THE SIZEWELL C PROJECT
(EN010012)

DEADLINE 2

**POST HEARING SUBMISSIONS INCLUDING WRITTEN SUBMISSIONS OF ORAL CASE
SUBMITTED BY THE HEVENINGHAM HALL ESTATE (THE HHE)**

(INTERESTED PARTY NUMBER: 20026675)

DRAWING TITLE:
NORTHERN PARK AND RIDE
PROPOSED PARAMETER PLAN

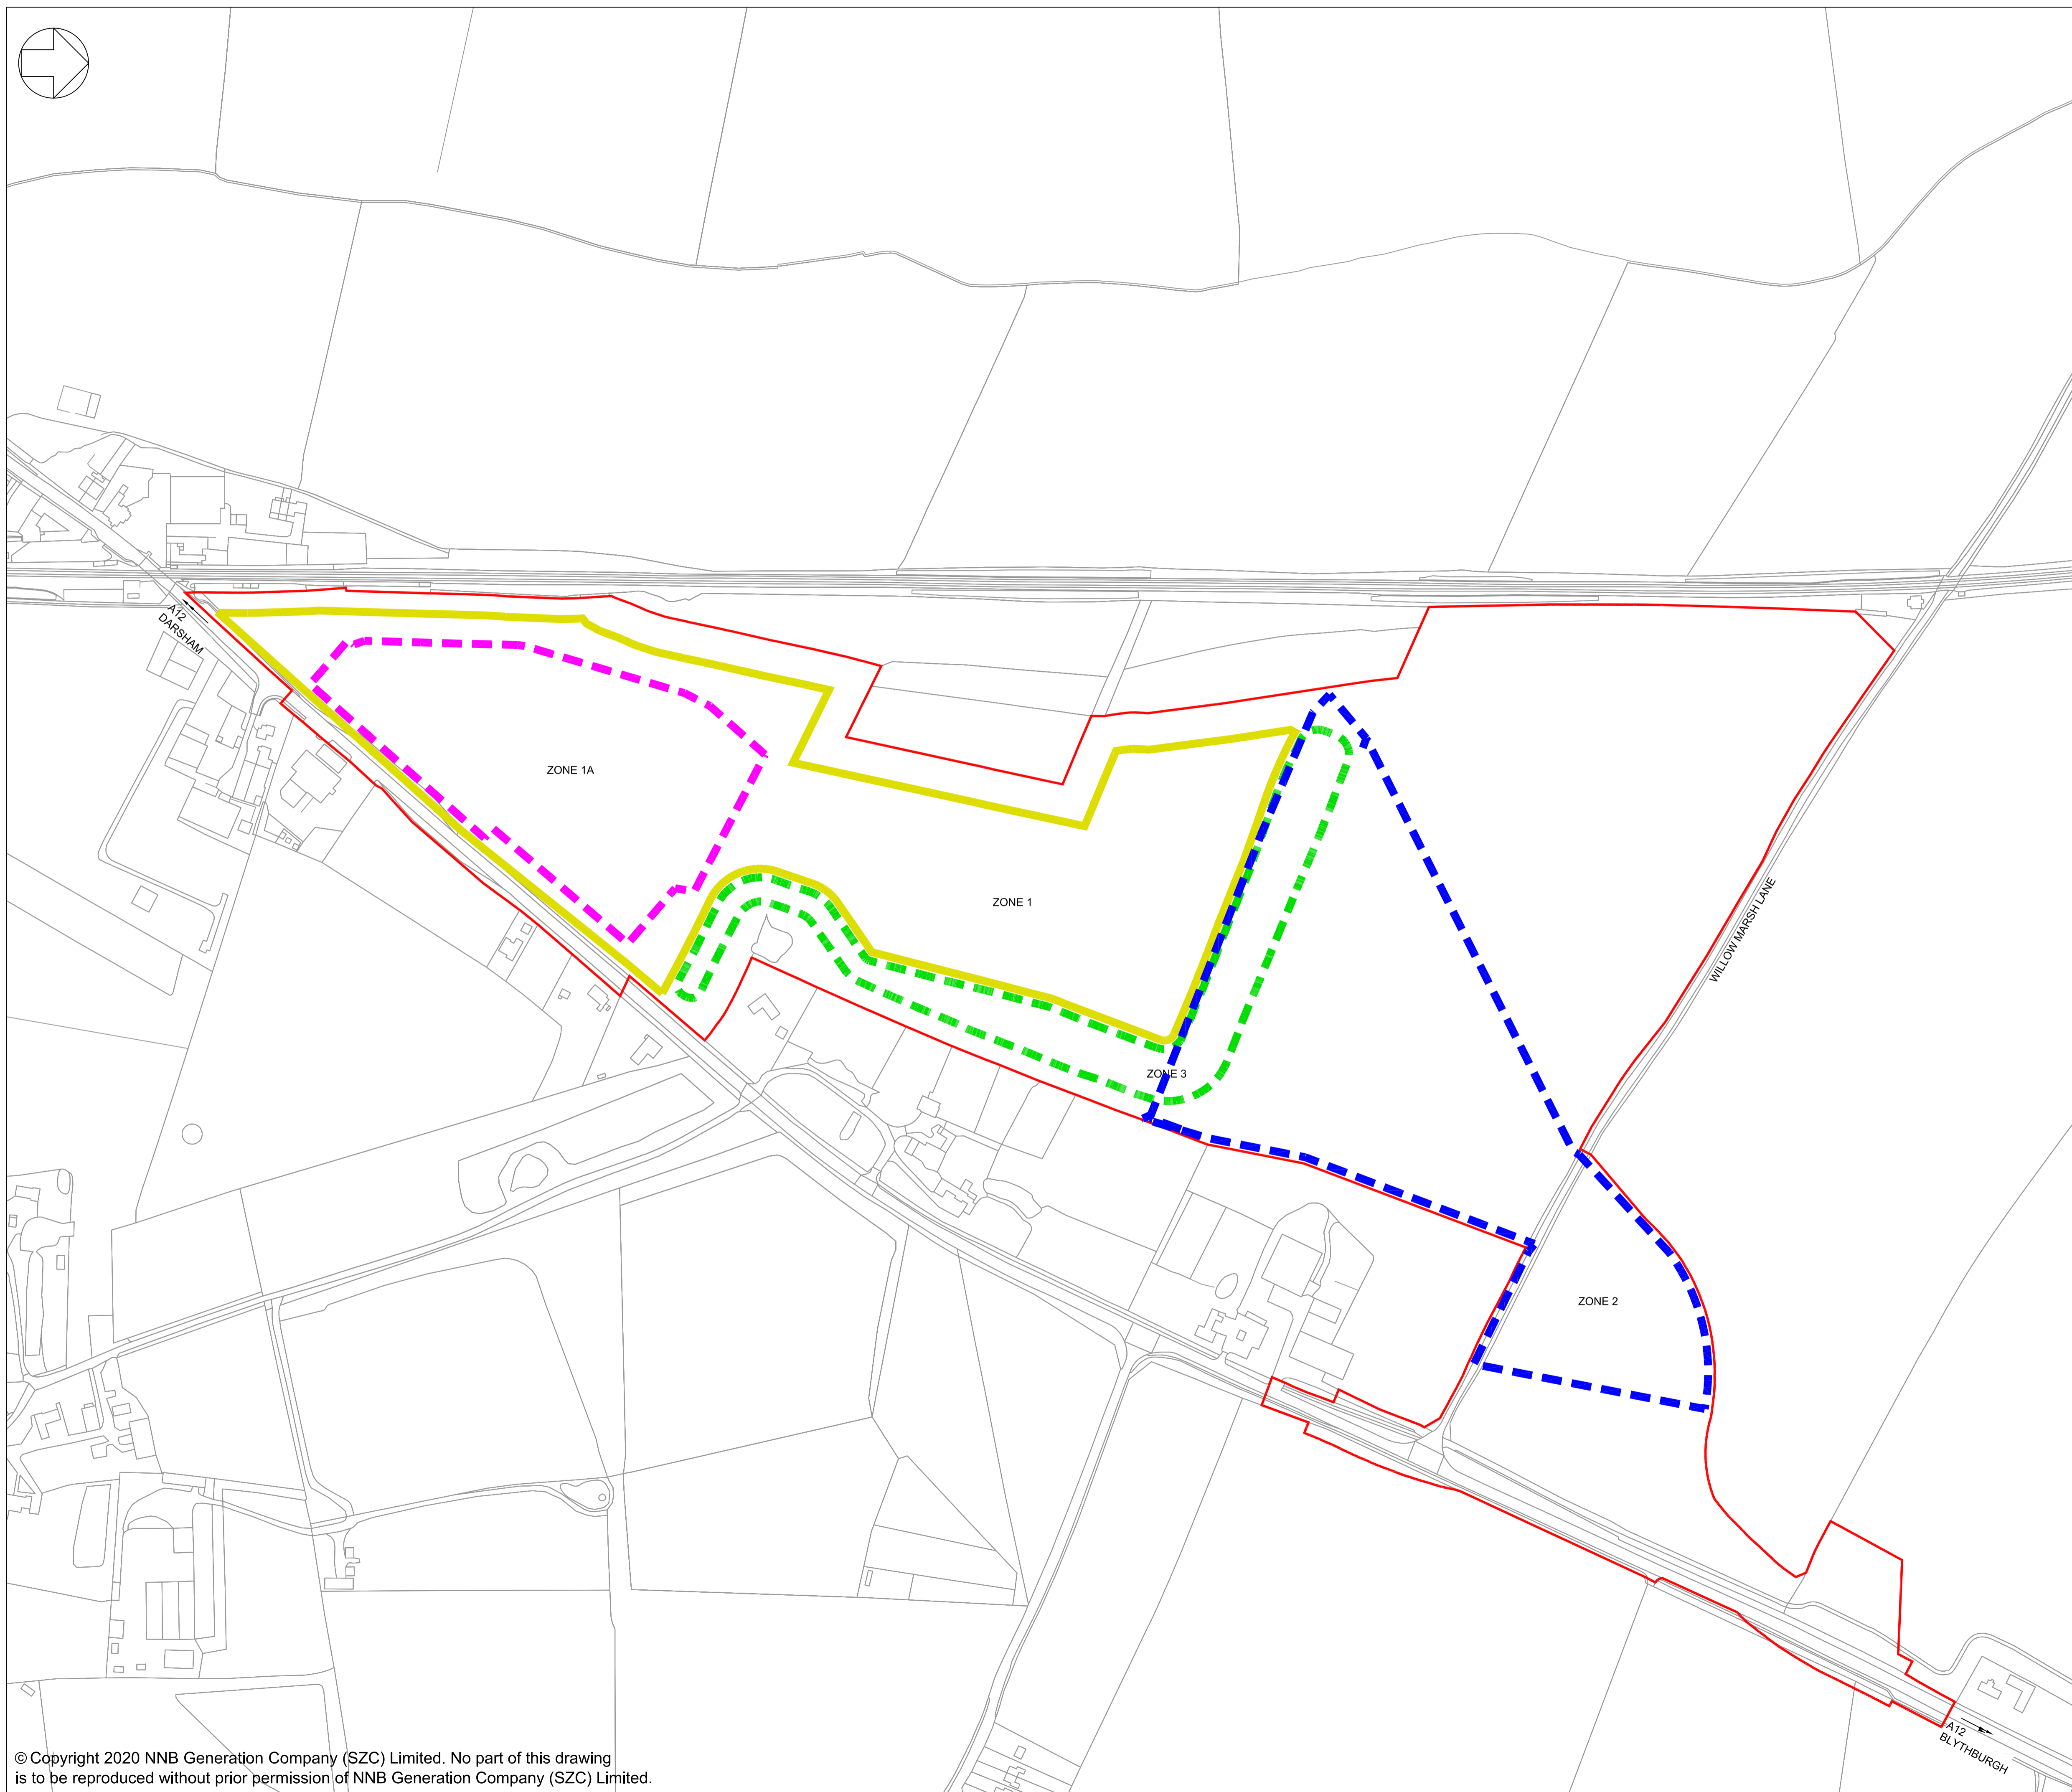
- (c) The NPR car park is unnecessarily large.
- (d) The HHE has serious doubts regarding the predictions relating to the use of the Northern Park and Ride – e.g. the modelling appears to assume that residents living west of Saxmundham who live closer to the Southern Park and Ride will use the Northern one.

- (e) The NPR has 1250 spaces, but the Addendum suggests 1054 spaces are necessary.
- (f) So far as the HHE is aware, the Applicant has not published any plan to ensure the effective management of the NPR once operational. This is of considerable concern, given that if not properly managed it will seriously impact local residential amenity.

DRAWING TITLE:
 NORTHERN PARK AND RIDE PROPOSED GENERAL ARRANGEMENT

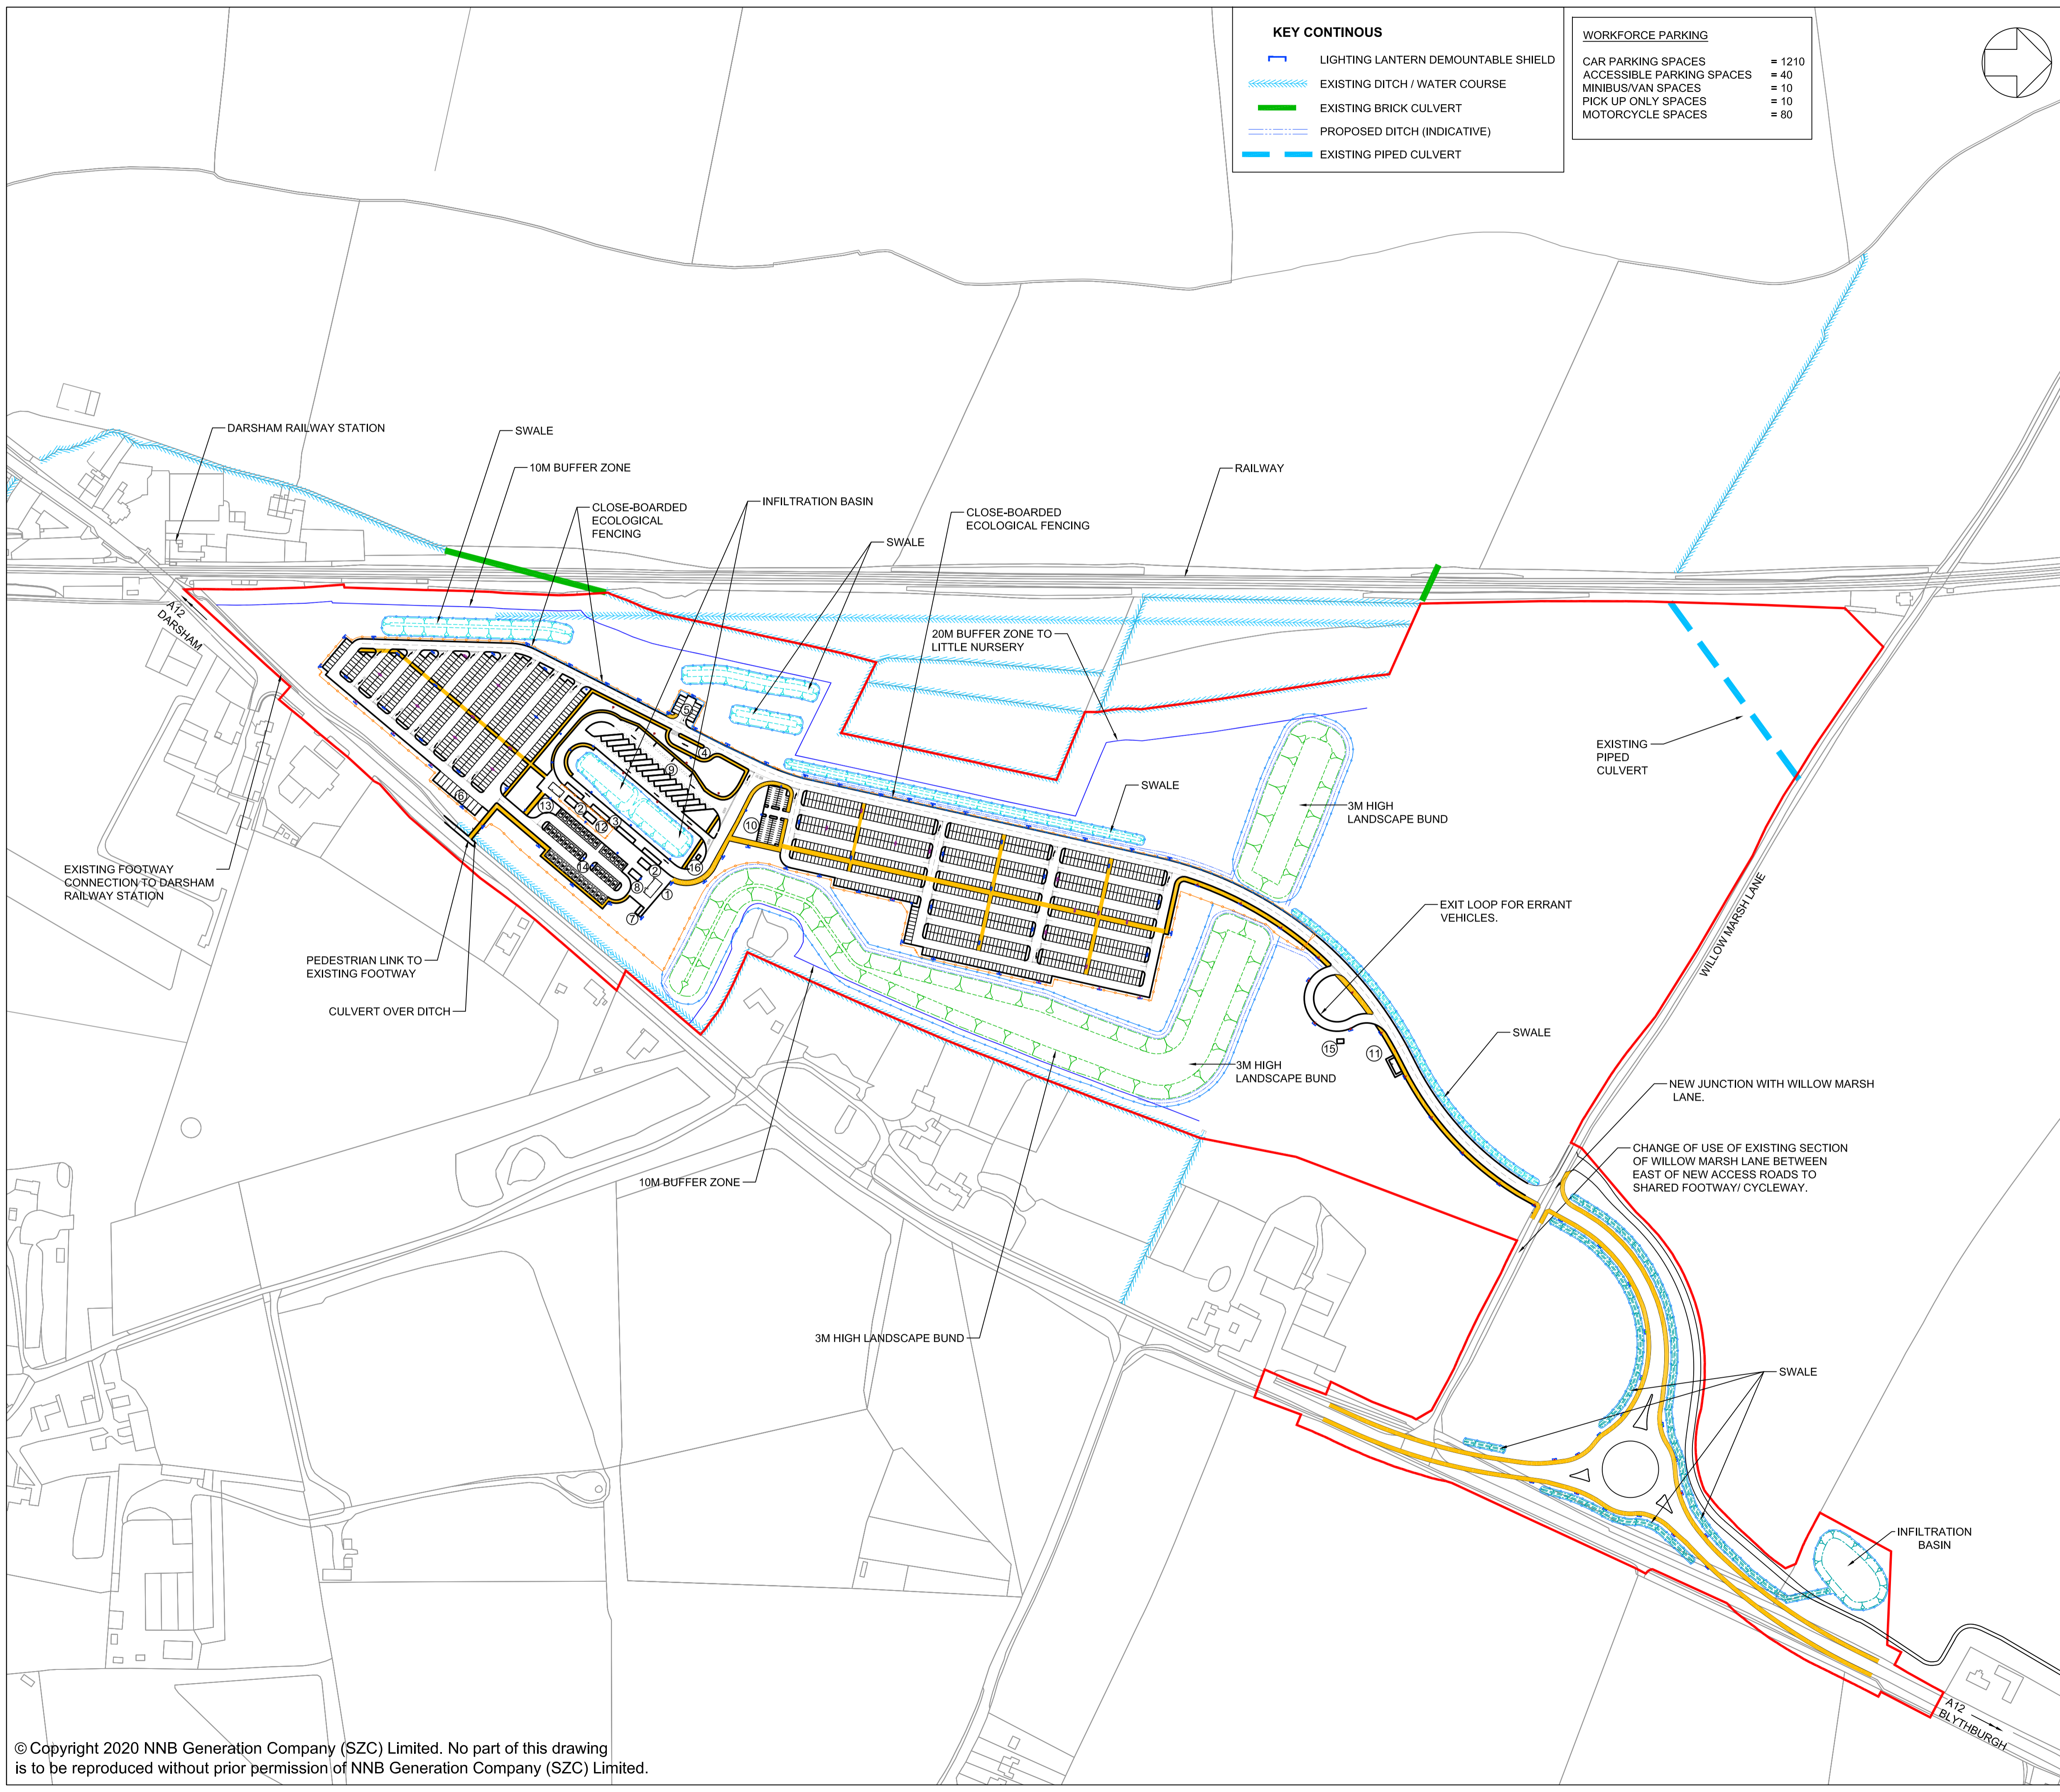
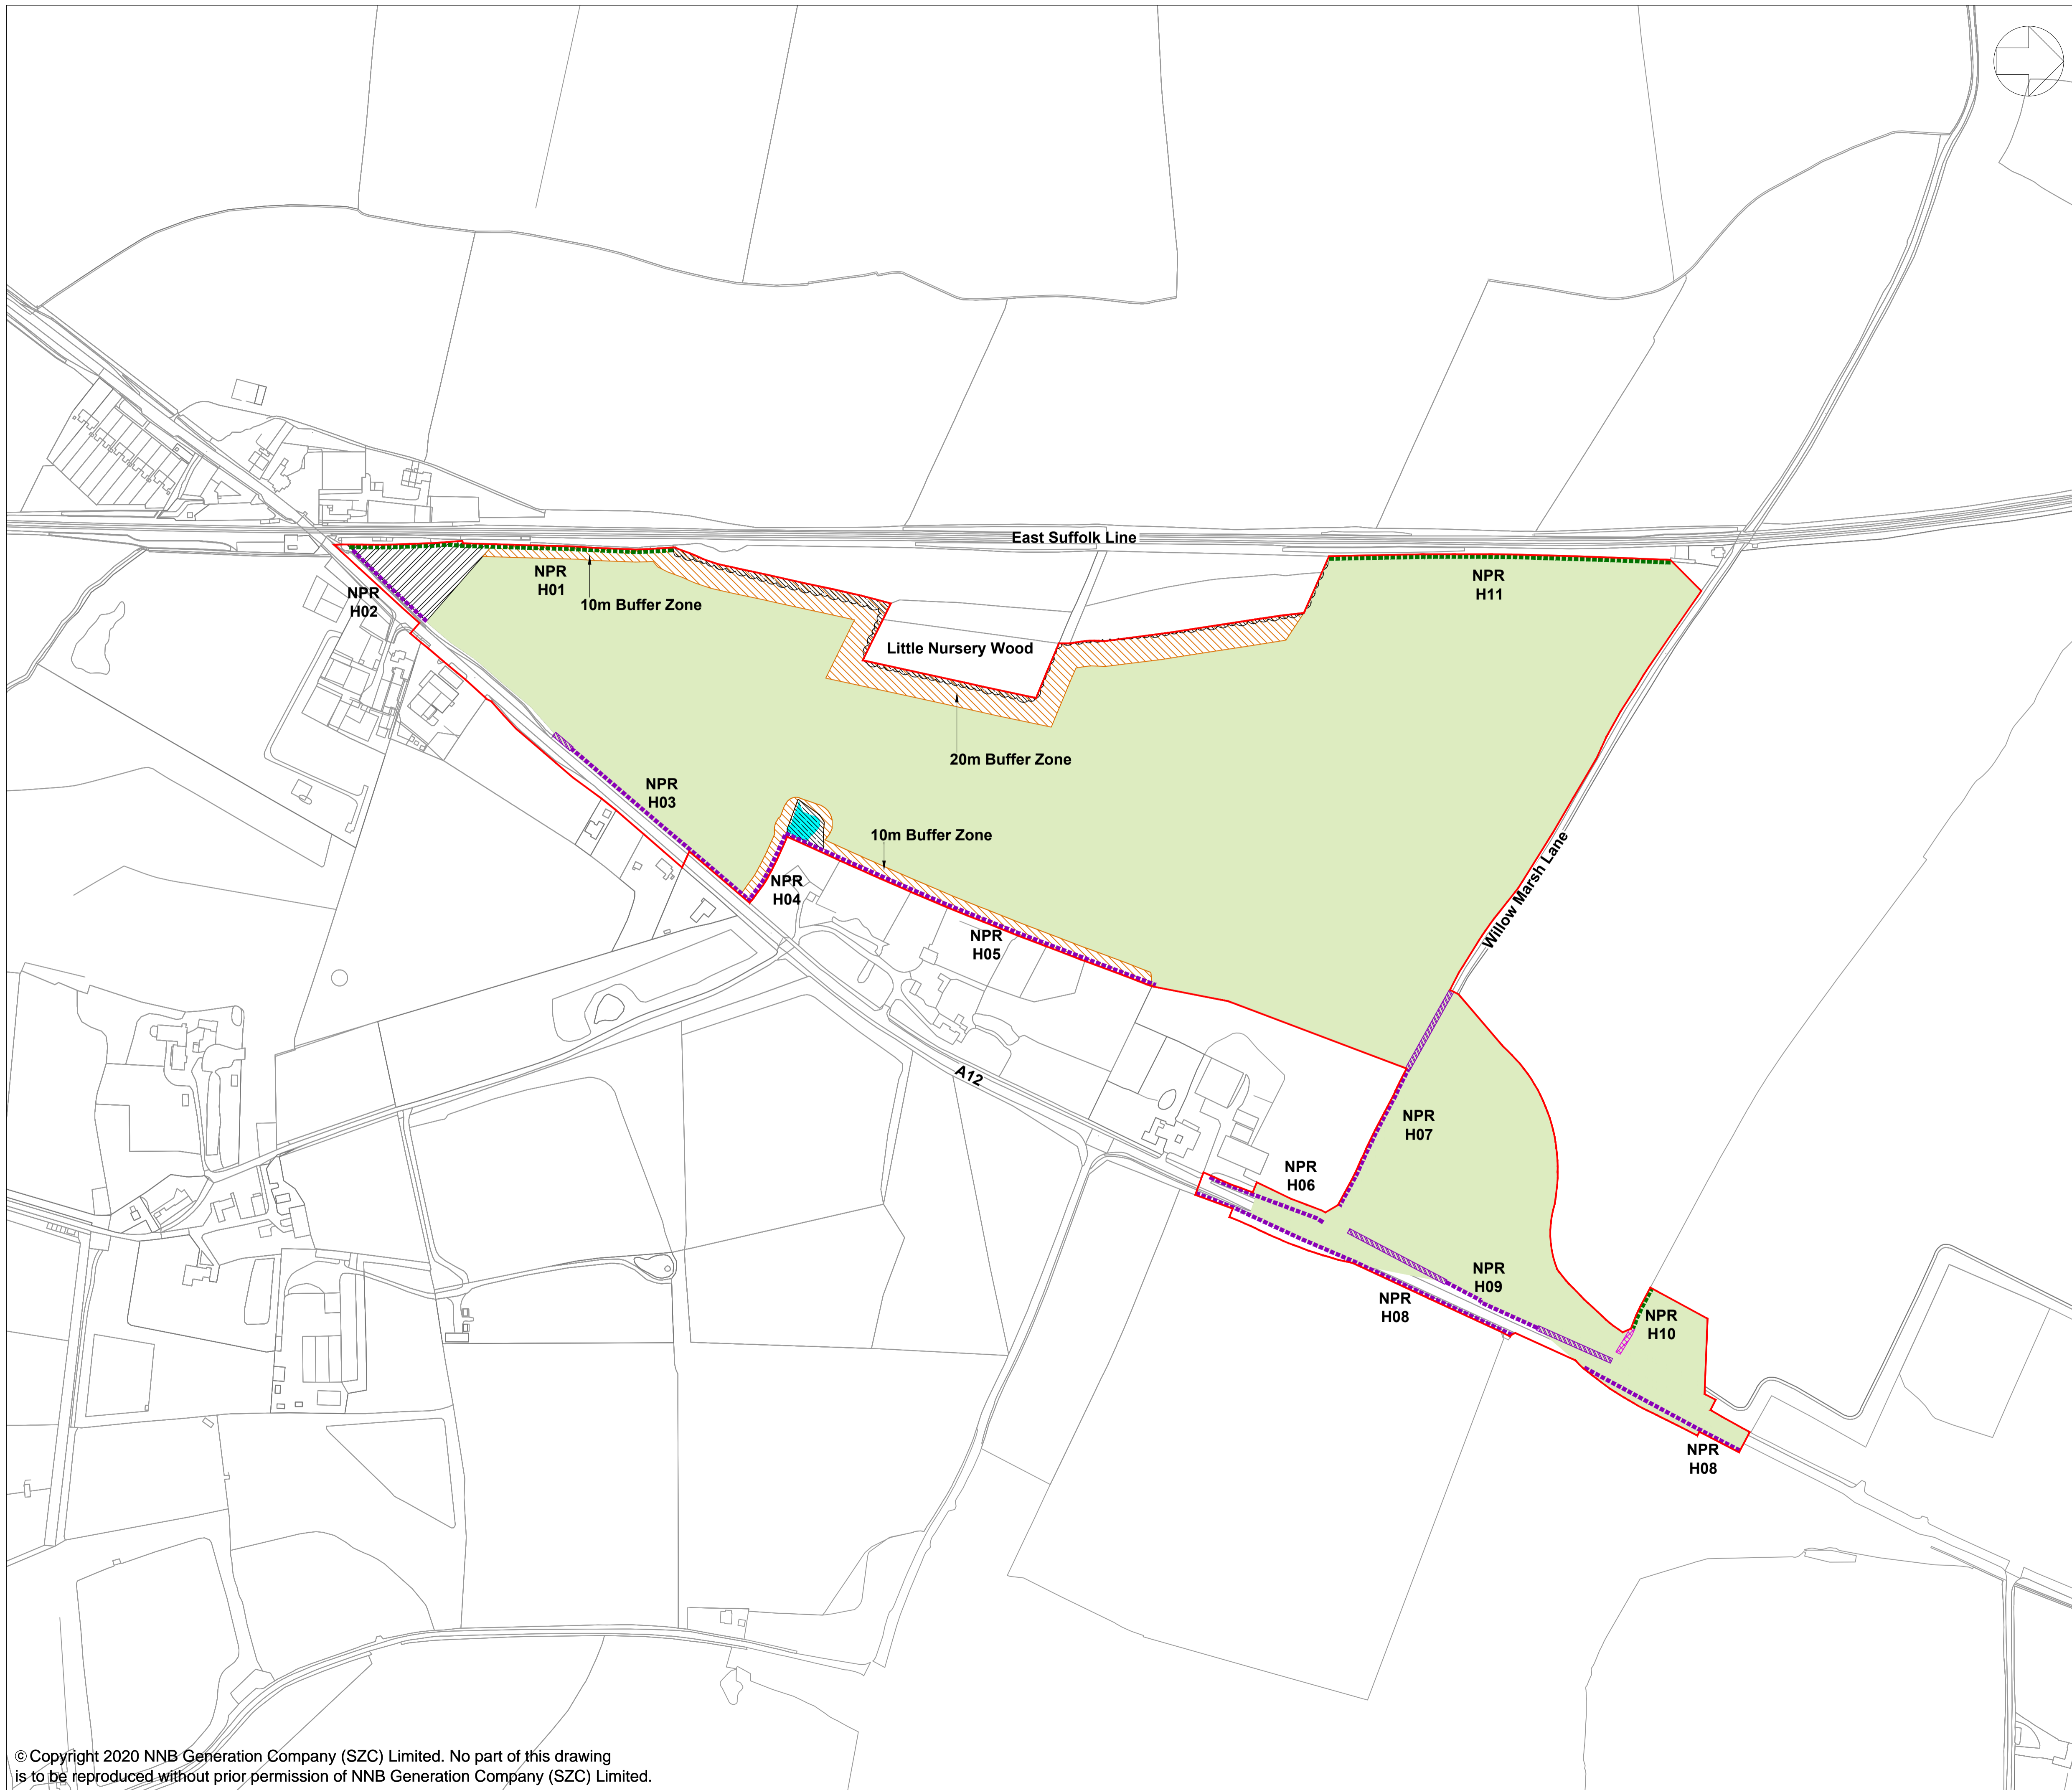
- (c) There are issues with the detail of the assessments undertaken, in particular:
 - (i) Great Crested Newts are known to be on site but have been scoped out of 8 waterbodies on the basis that the A12 presents a substantial barrier to their movement. Ecology Solutions analysis suggests this is incorrect and Great Crested Newts have been under assessed.

- (ii) No proper consideration has been given to whether Little Nursery Wood is ancient woodland – despite the fact that it supports indicator species and the description of it in SZC's 2011 Phase 1 survey as "a remnant of ancient semi natural woodland".

- (iii) No consideration has been given to bats and reptiles potentially present on the site.
